STATE OF NORTH CAROLINA
DEPARTMENT OF TRANSPORTATION

Addendum No. 1

RE: Contract ID: C201594
WBS# 38724.3.1
F. A. # IMS-095-1 (59) 22
Robeson County (I-4711)
I-95 From US-301 (MP-22.1) to the
Cumberland County Line (MP-39)

April 18, 2006 Letting

TYPICAL SECTION NO. 6

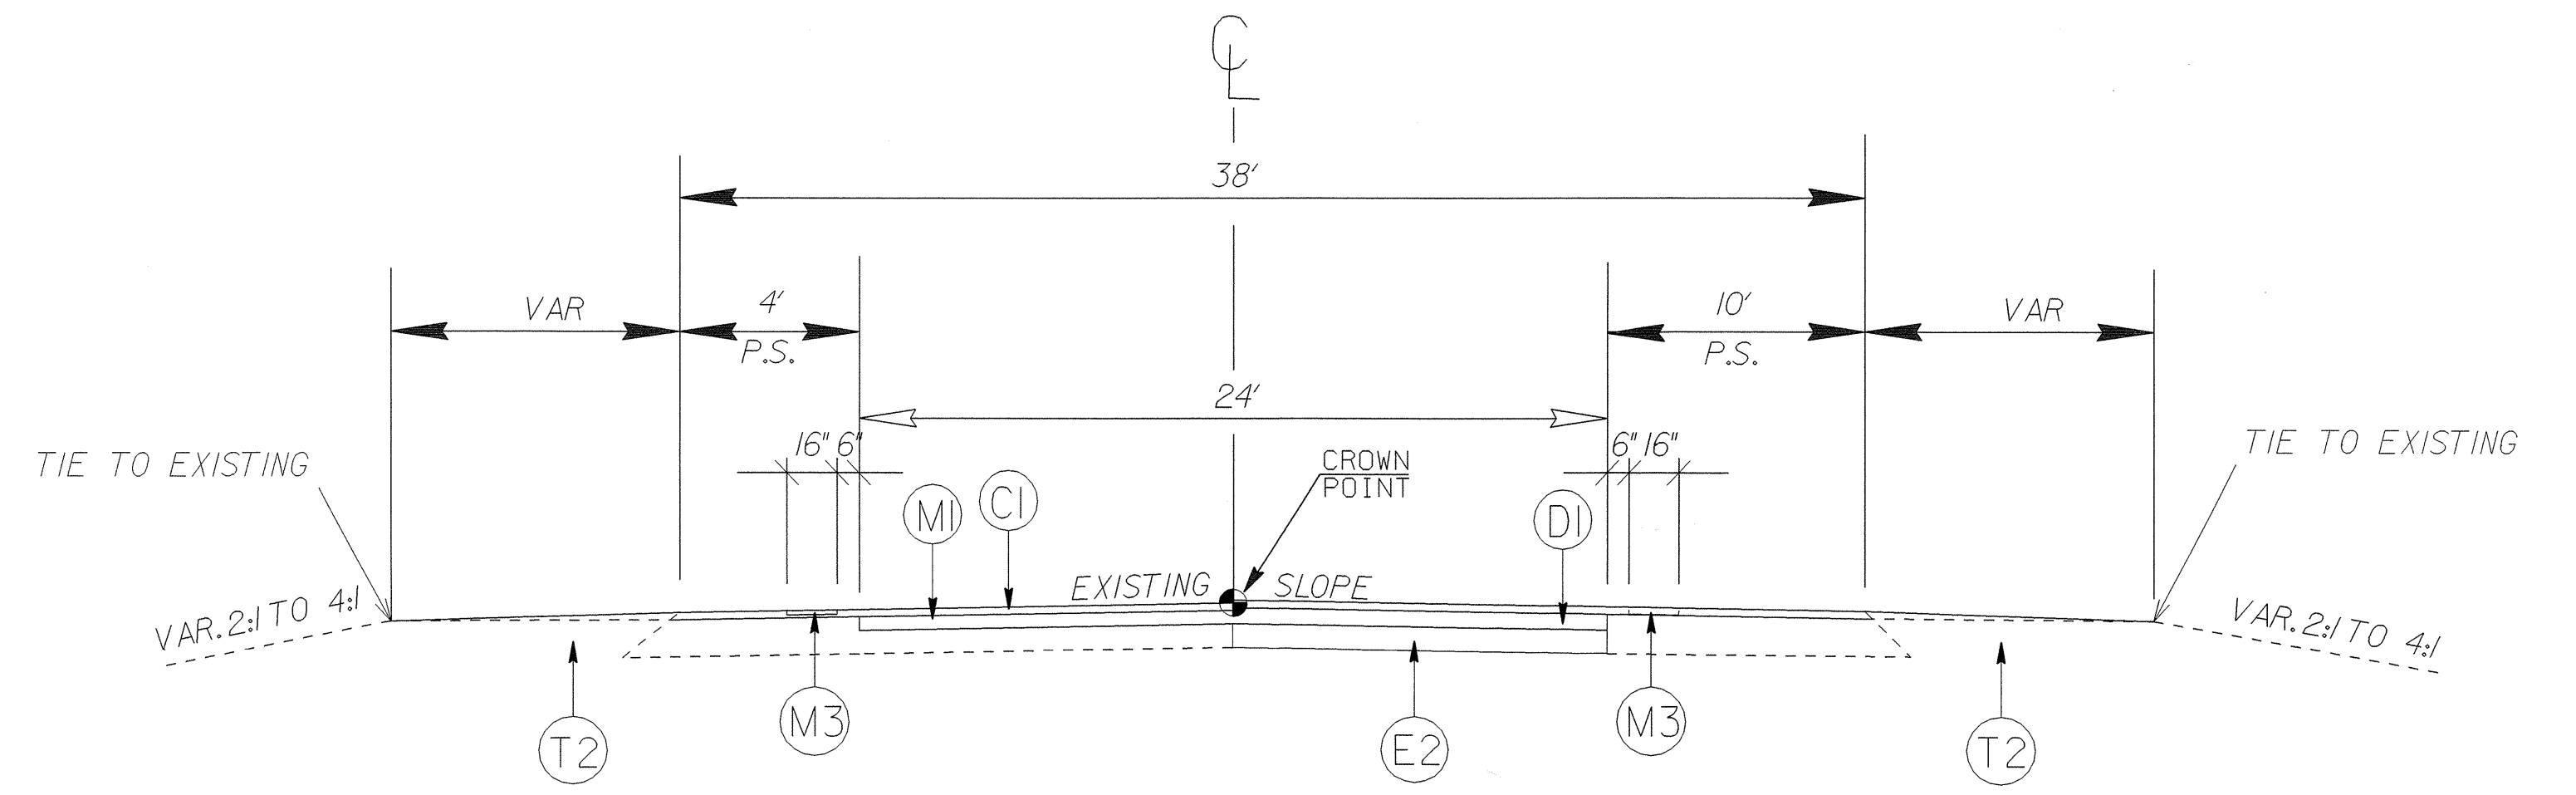
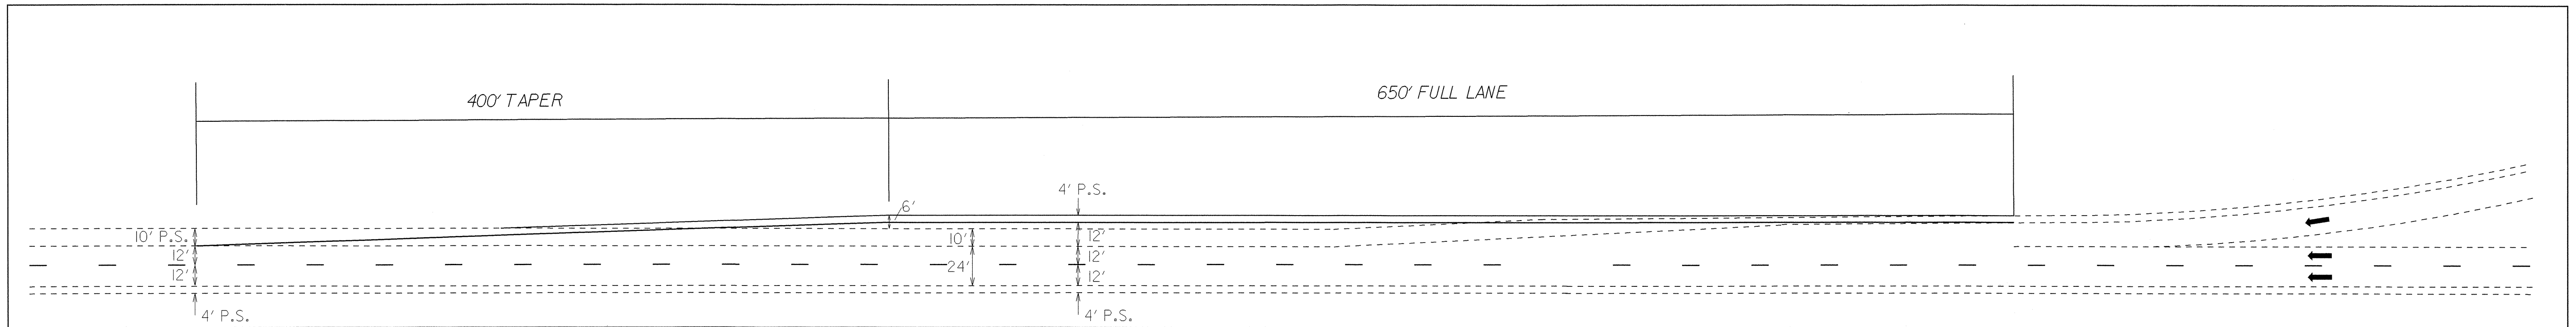
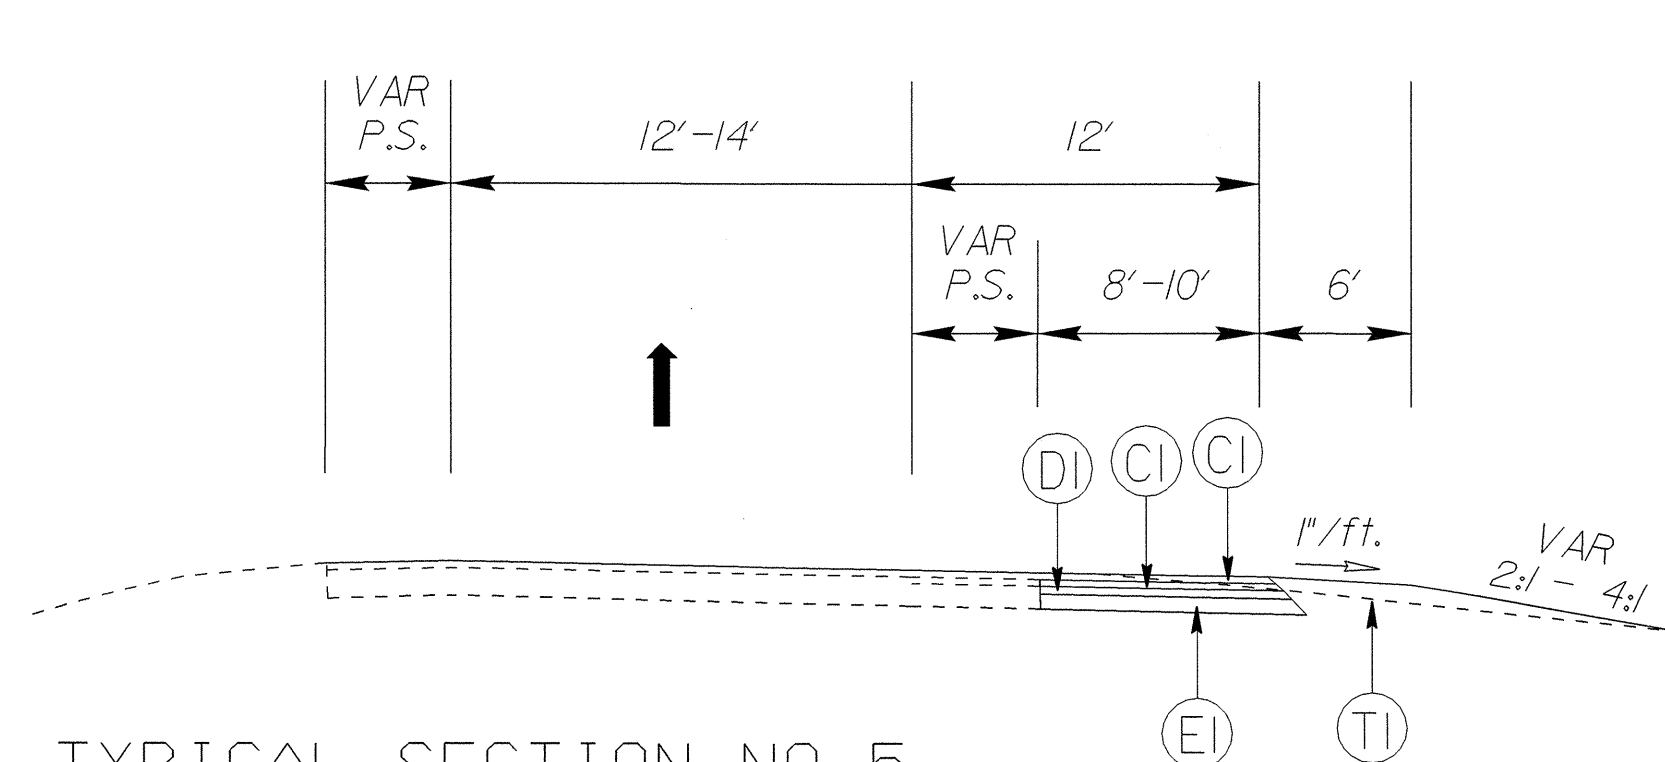
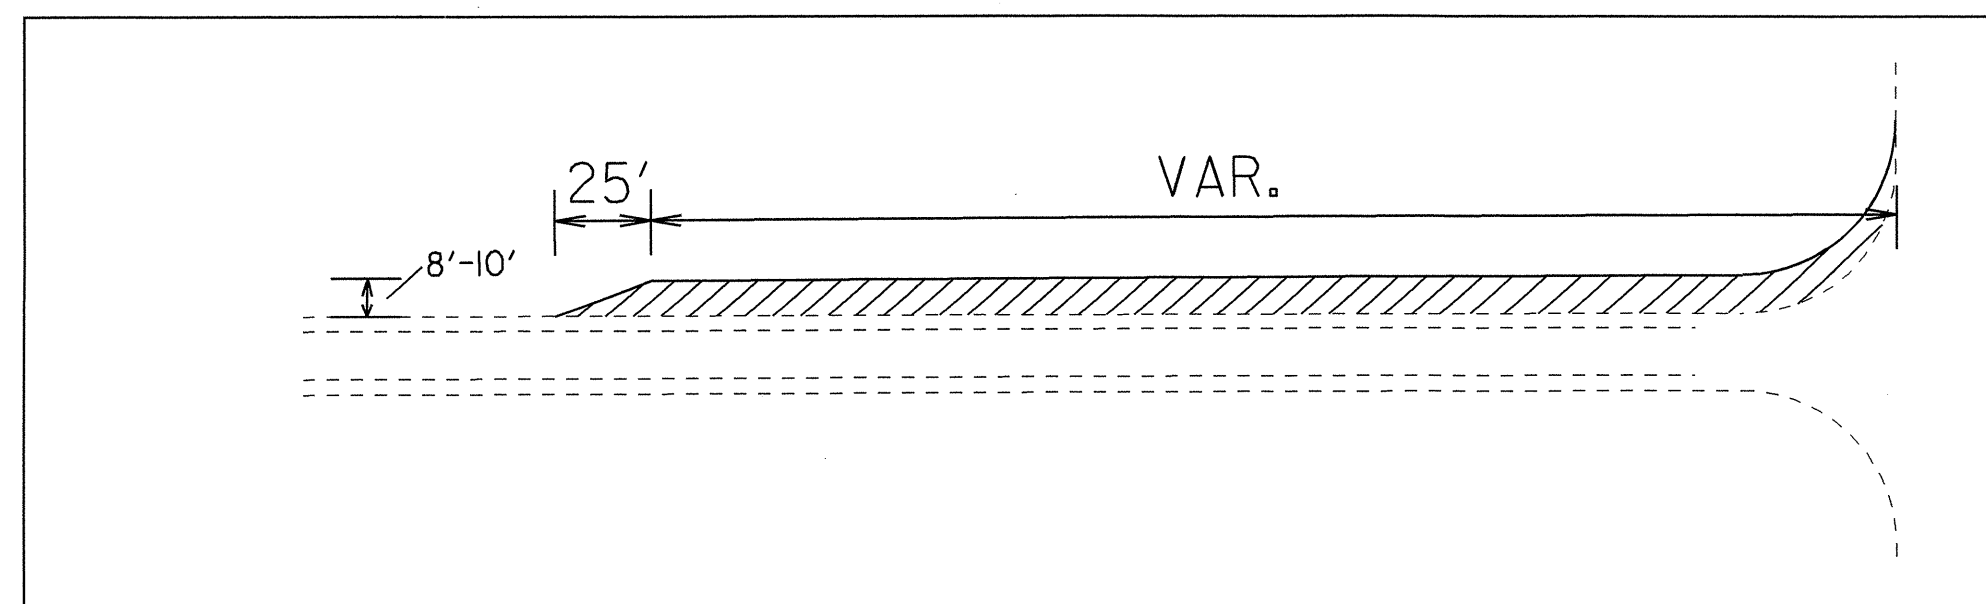
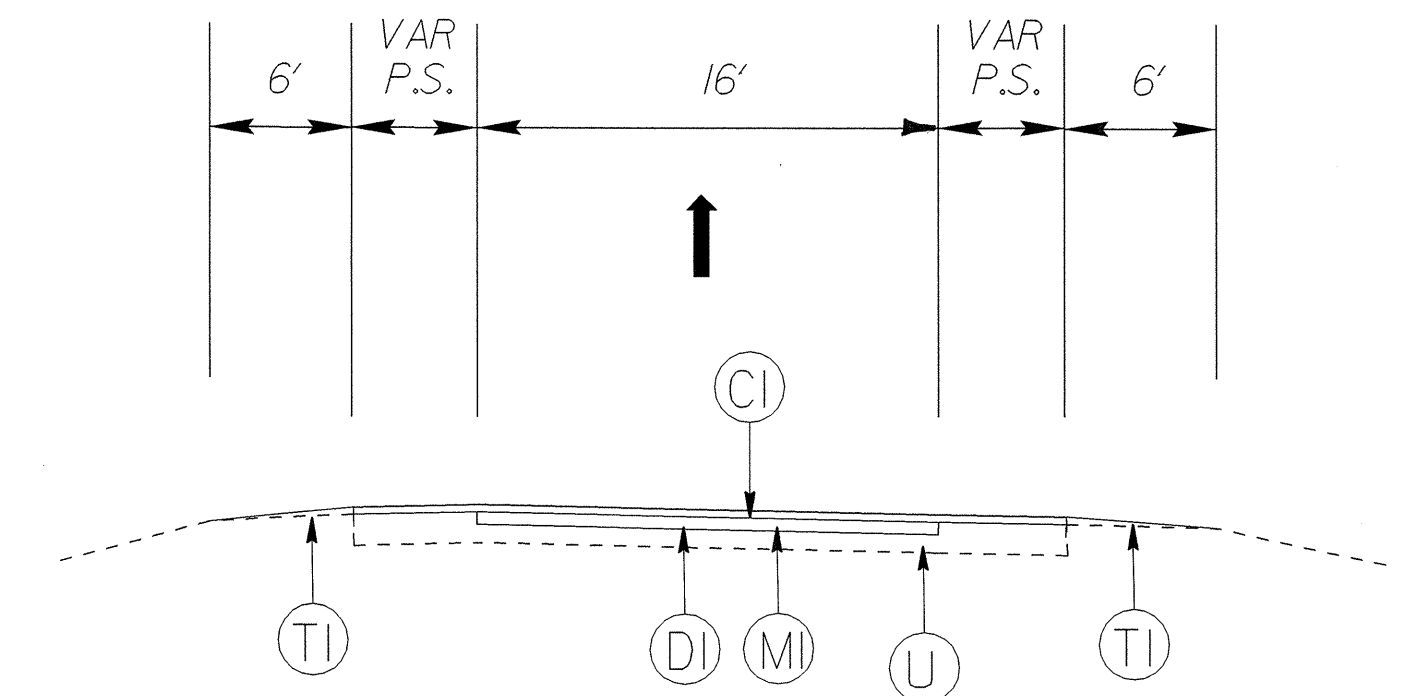
Sheet No. 2-A has been revised to add "Typical Section No. 6" for use on the ramps at Exit Nos. 25, 31, and 33. Please void Sheet No. 2-A in your plans and staple the revised Sheet No. 2-A thereto. The quantities for the work reflected in this new typical are already included in the existing line item quantities.
